From: Geoff Thorpe <[REDACTED]>
Sent: 27 June 2019 10:59
To: Planning
Subject: Applications AB/48/19/PL and AB/49/19/L - for the attention of Mrs Gardner

Having read Martyn White's planning response to the above applications, posted on the Arun planning portal, please can I, on behalf of the applicant confirm/ advise as follows:

A6001-05

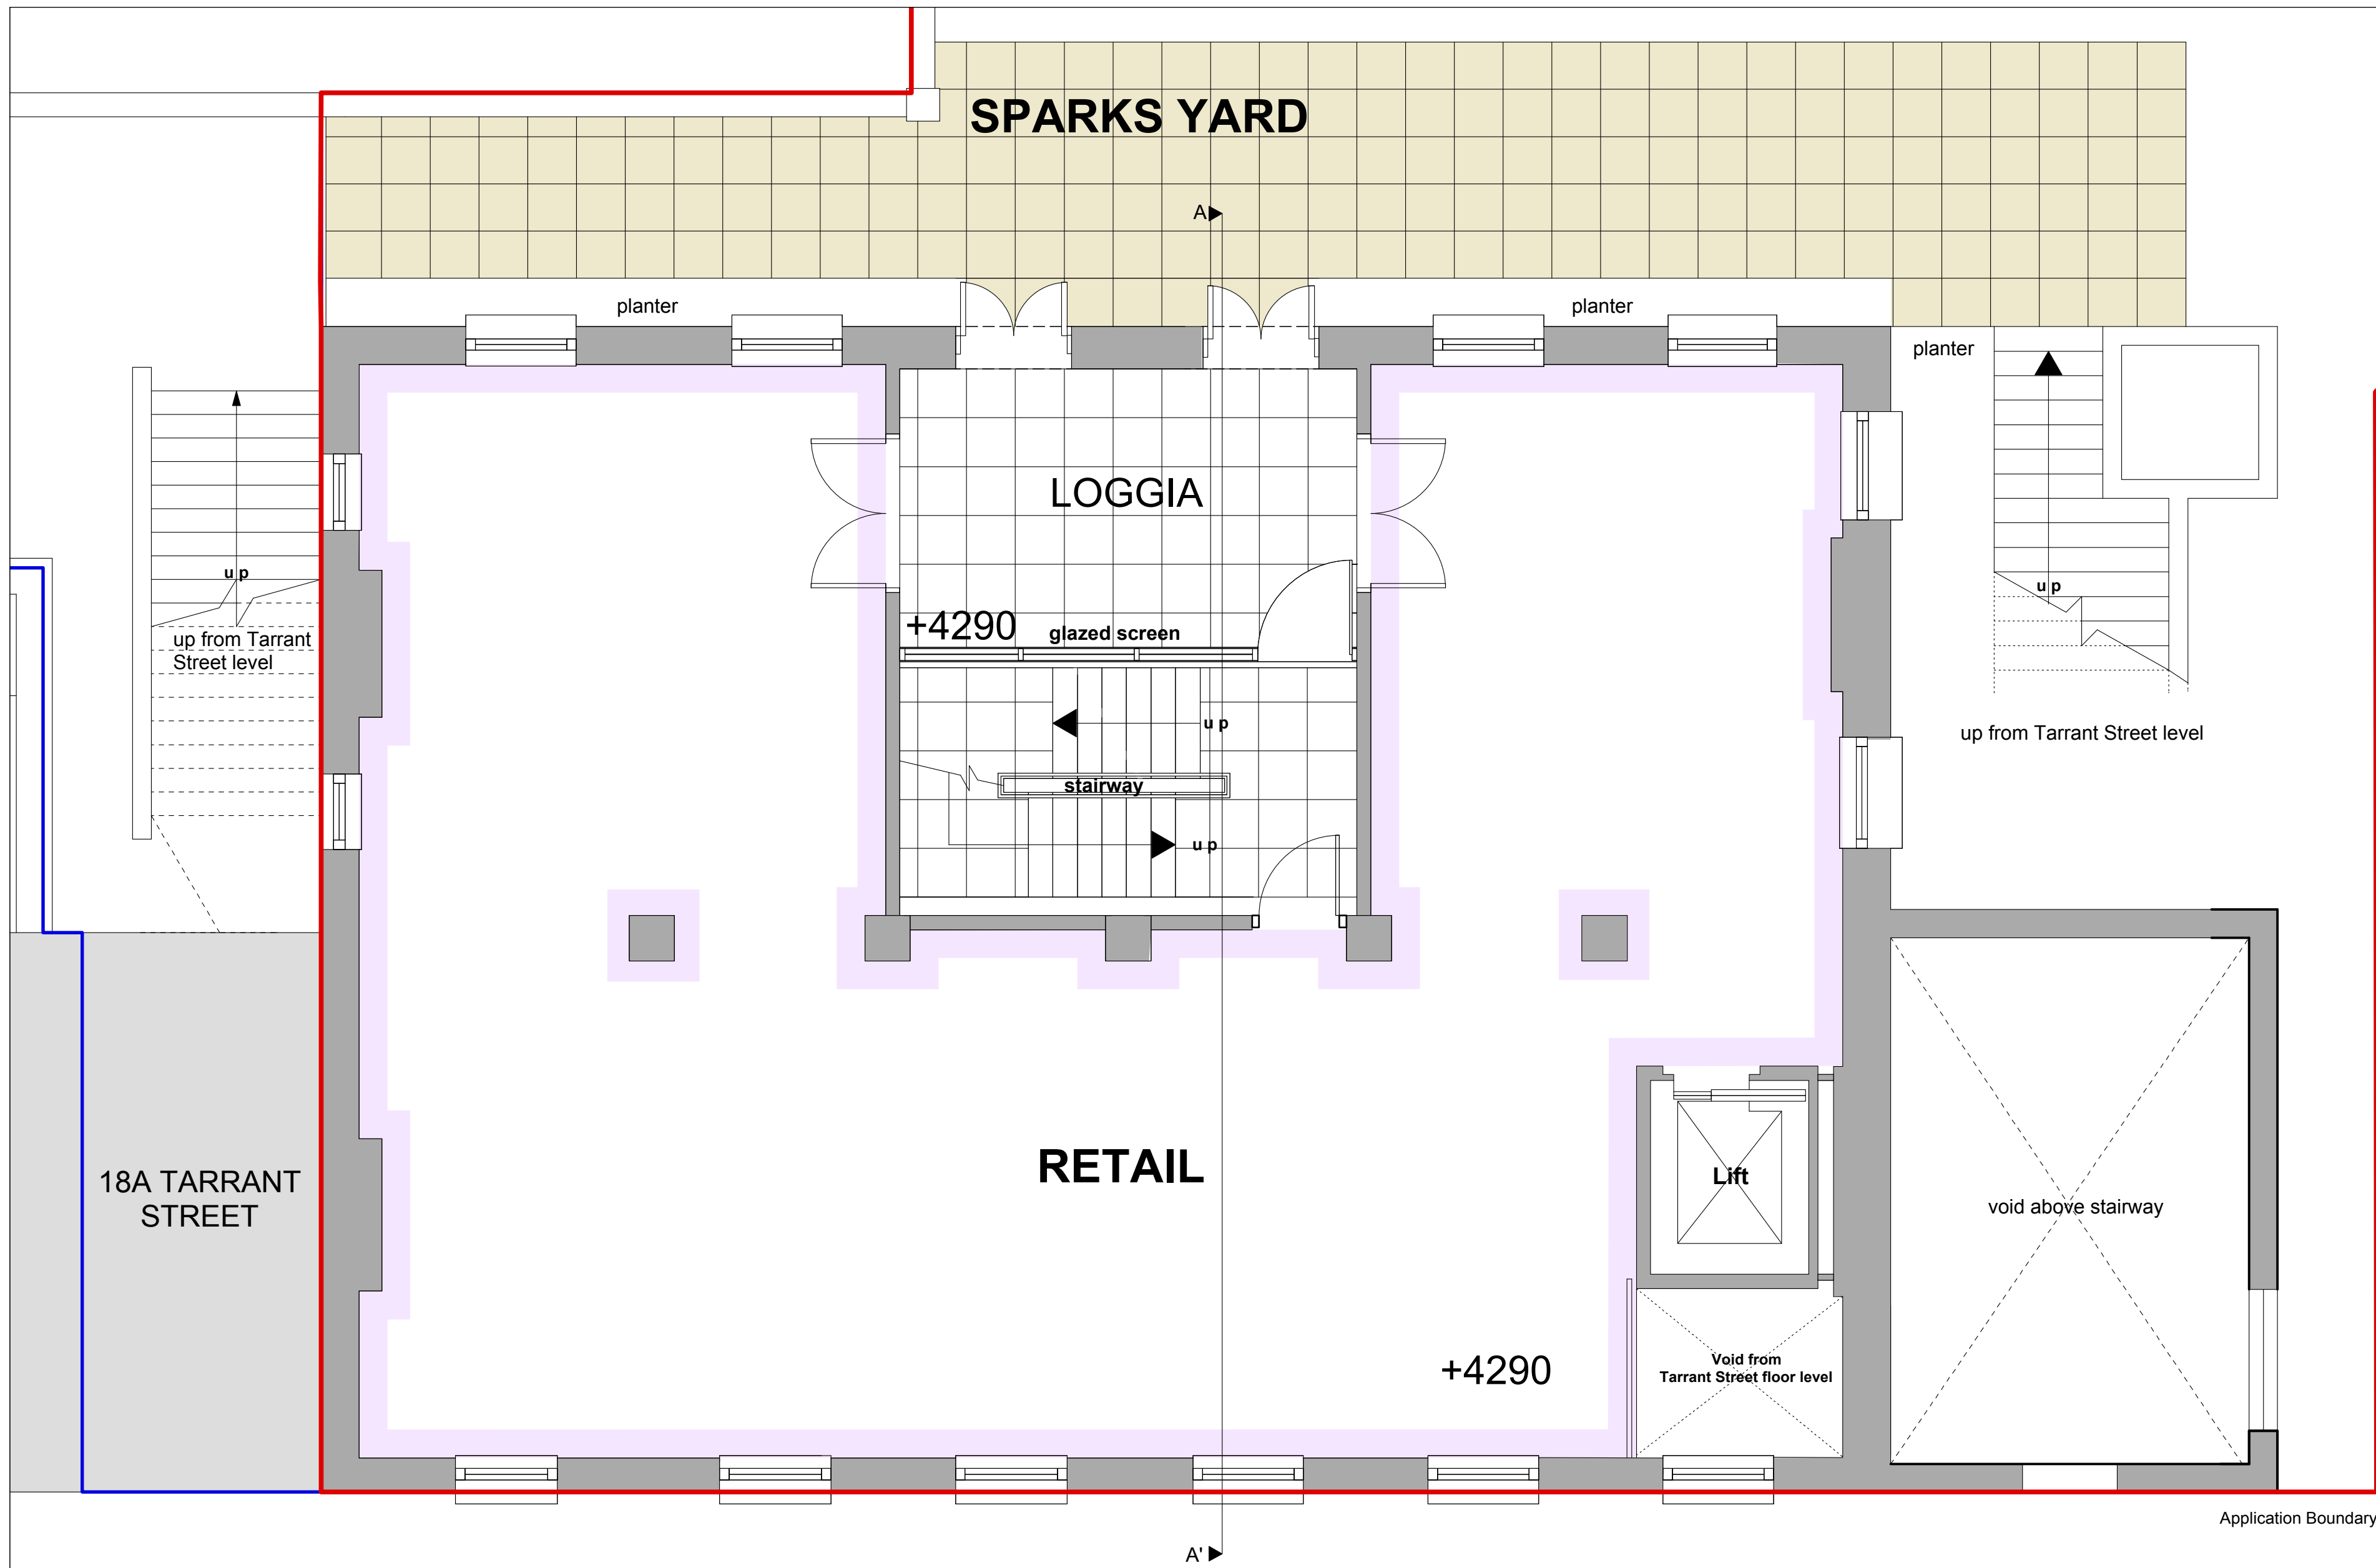
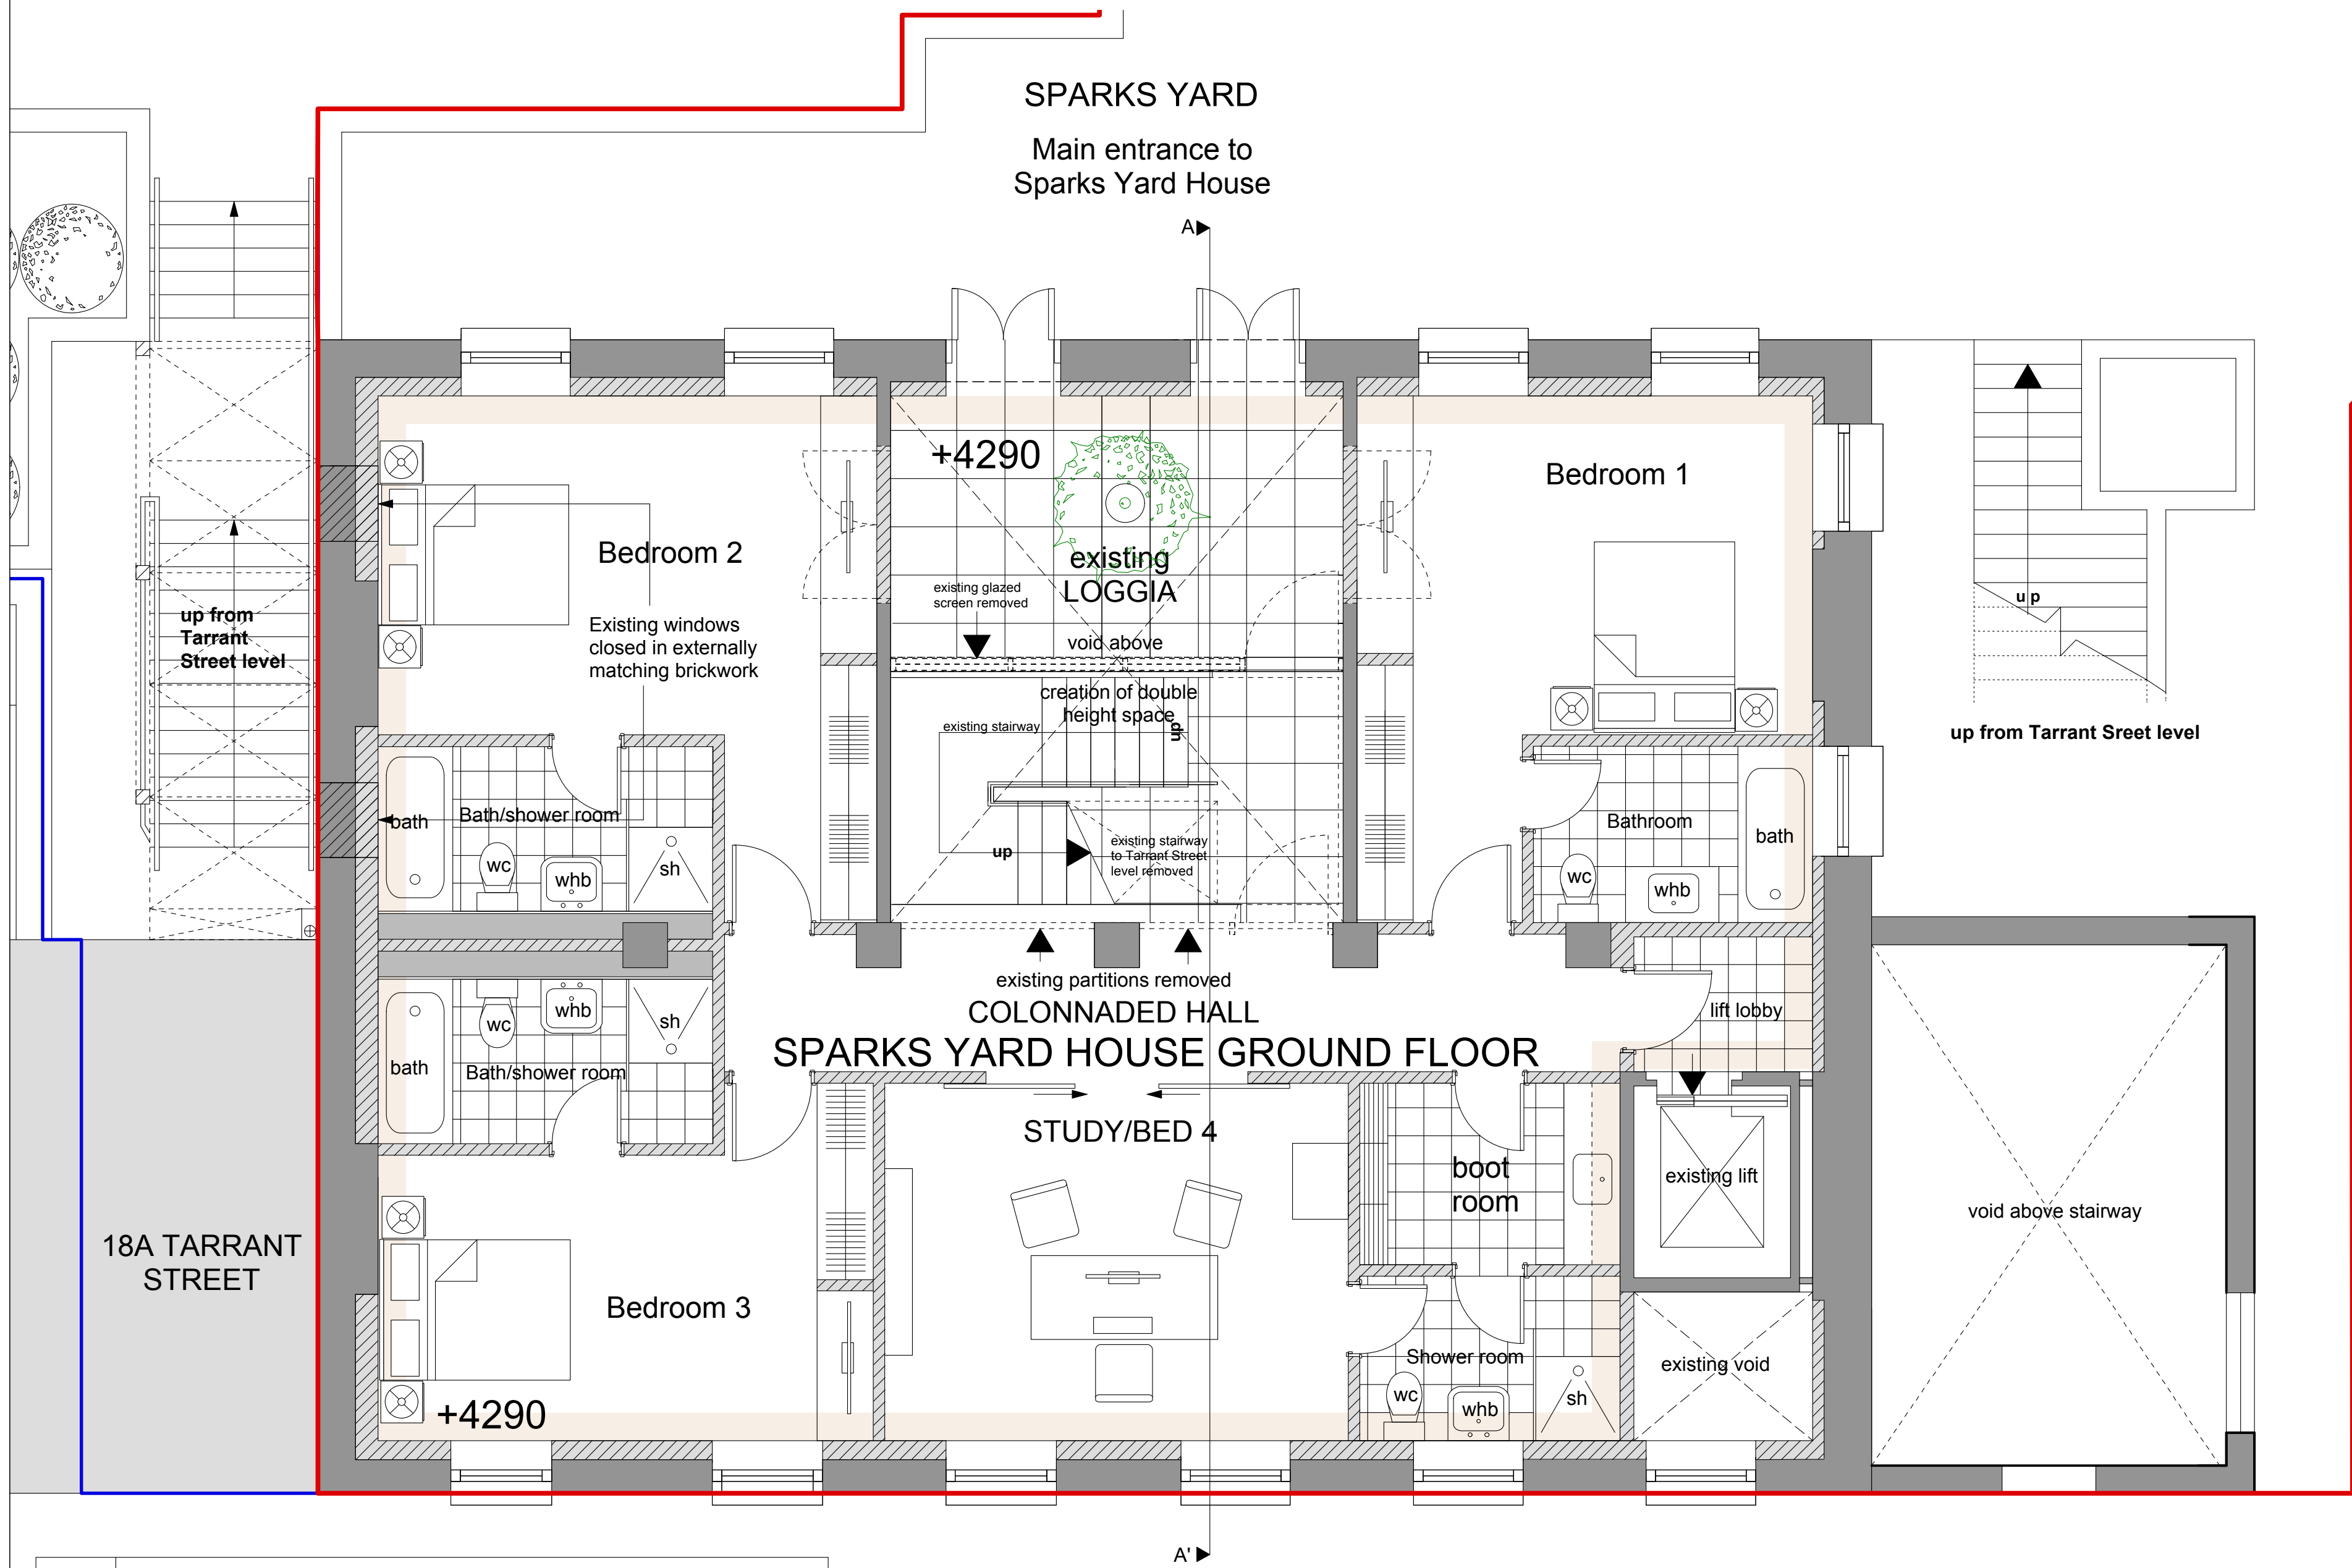
2. I am delighted to read the concerns relating to the lining of the external brick walls with insulation and plasterboard. We do not wish to do this and it was only included in the proposal in order to satisfy the inevitable thermal insulation requirements of building regulation approval. I confirm therefore that we wish to amend our applications in order to remove all proposed external wall linings to the upper two floors of the buildings and will seek an agreement to relaxation when the building regulation approval

application is made, citing its unacceptability for inclusion within this listed building. Would you like us to submit amended drawings to cover this or can this be covered by a potential condition?
